Phone: 0300 123 6780
Email: developeras@lancashire.gov.uk
Your ref: 3/2025/0083
Our ref: 3/2025/0083/HDC/KW
Date: 28 May 2025

Location: The Works Talbot House Main Street Gisburn
Proposal: Proposed construction of a self-build, detached house with granny annex and double garage together with conversion of existing live/work unit to form workshop space to be utilised by the occupiers of the dwelling.
Grid Ref: 382899, 448888

Summary

No objection subject to condition

**Project No:** DRIV/01 Dwg 06 **Drawn:** EP

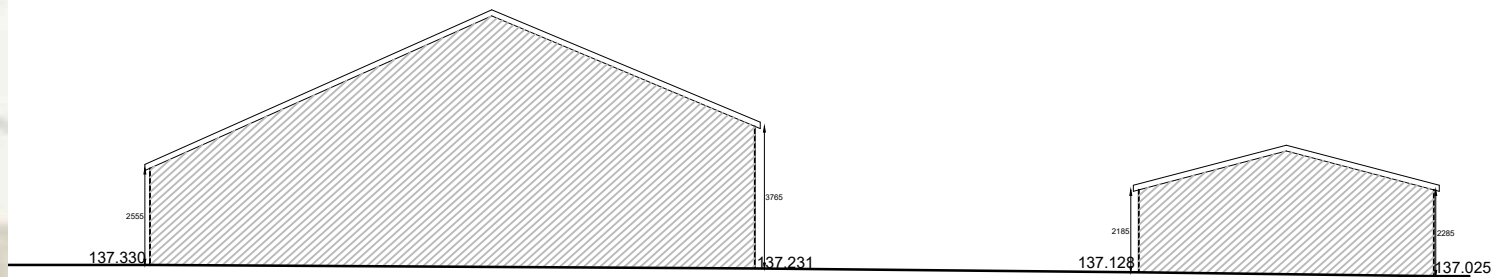
The LHA have reviewed the site plan, drawing number DRIV/01 Dwg 06 and the location plan, drawing number DRIV/01-Dwg 04 and are aware that the proposed dwelling complies with the LHAs parking standards as defined in the Joint Lancashire Structure Plan.

PROPOSED GARAGE FLOORPLANS AND ELEVATIONS  
SCALE - 1:50@A1

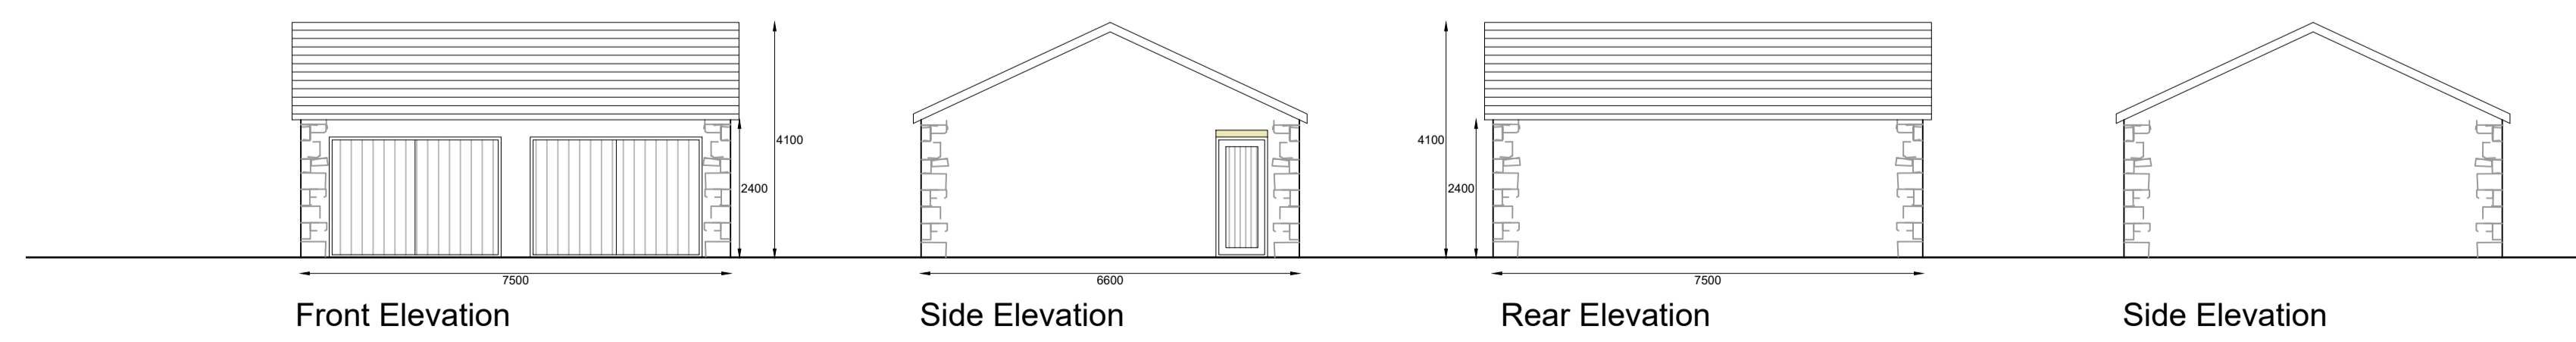
The proposed garage also meets the LHA recommended internal measurements for a double garage which is 6m wide and 6m long as such the garage offers acceptable off street parking provisions.
